Current Zoning: INST(CD) (Institutional, Conditional)
Proposed Zoning: INST(CD) SPA (Institutional, Conditional, Site Plan Amendment)

Approximately 40.43 acres located on the east side of Johnston Road, south of Providence Road West.

The petition proposes to amend a previously approved plan to allow for additional entitlements to a hospital and associated medical, dental, and optical offices and clinics. The petition would allow an additional 56,000 square feet in medical office uses and 13,000 square feet and 48 beds in health institution entitlements.

Staff recommends approval of this petition upon resolution of outstanding issues related to transportation and site and building design.

RZ-2
REZONING

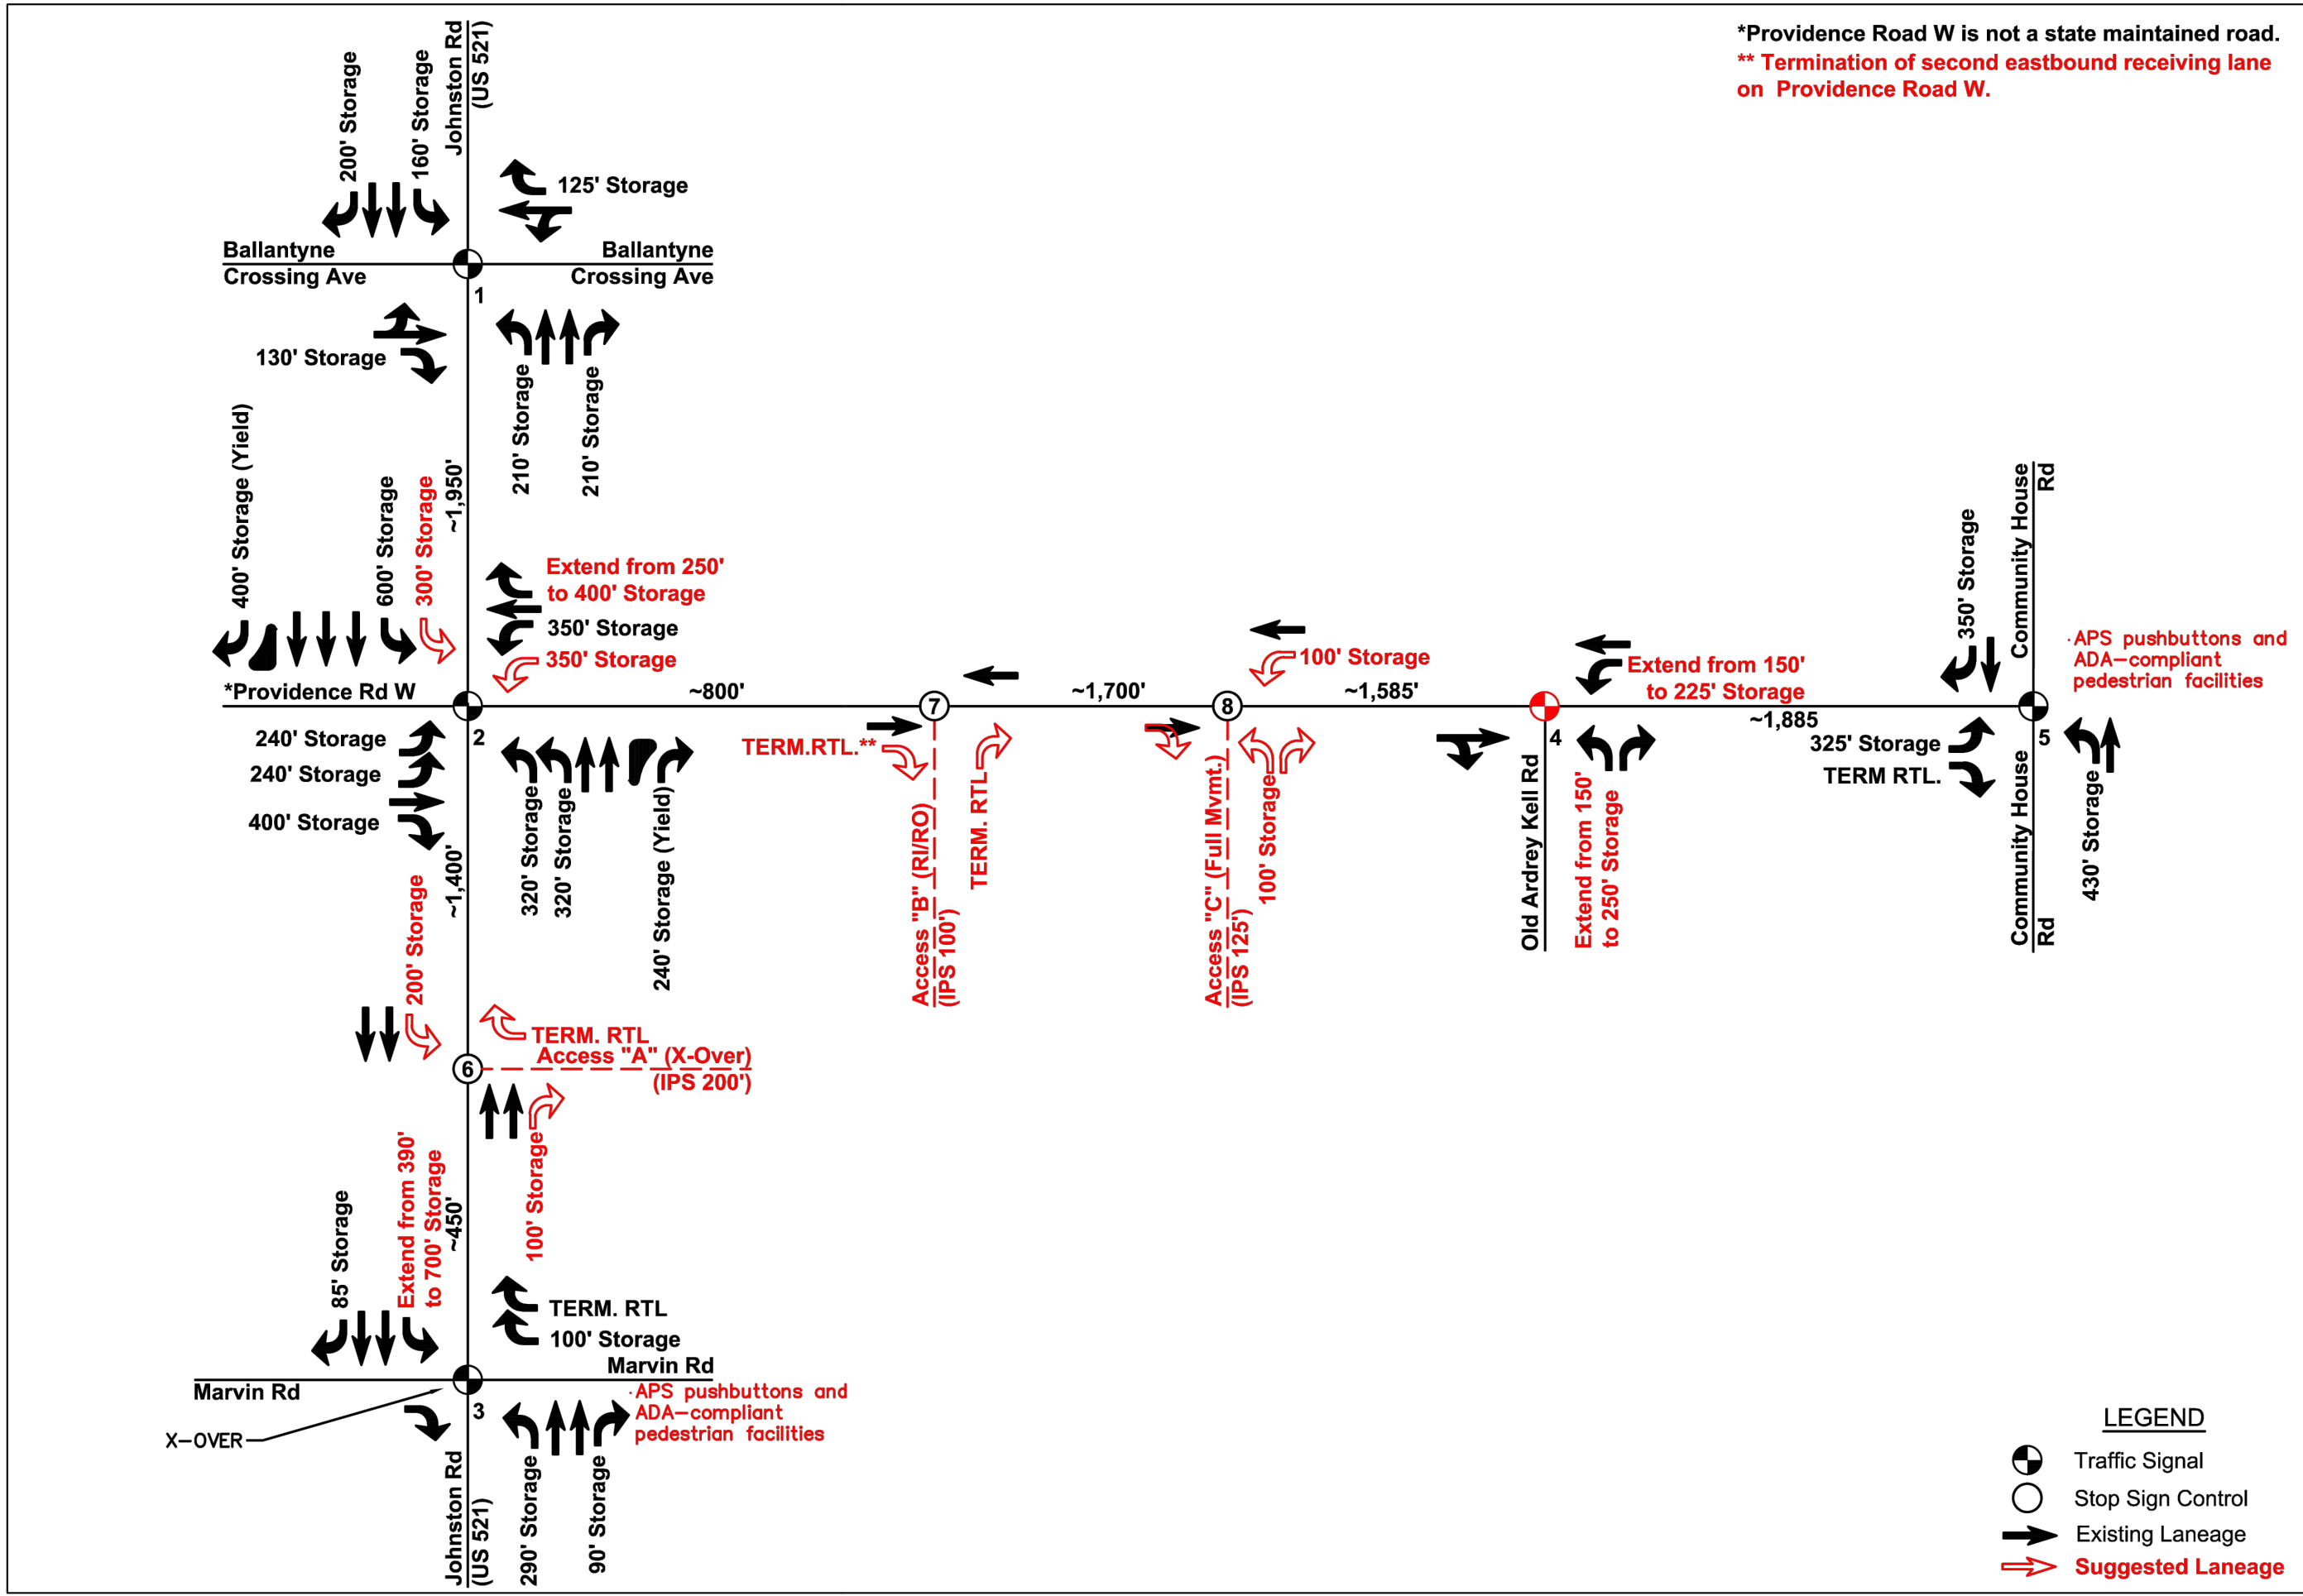
1. Update the site plan and Exhibit A to show the new leftover per updated TIS at "Access B".
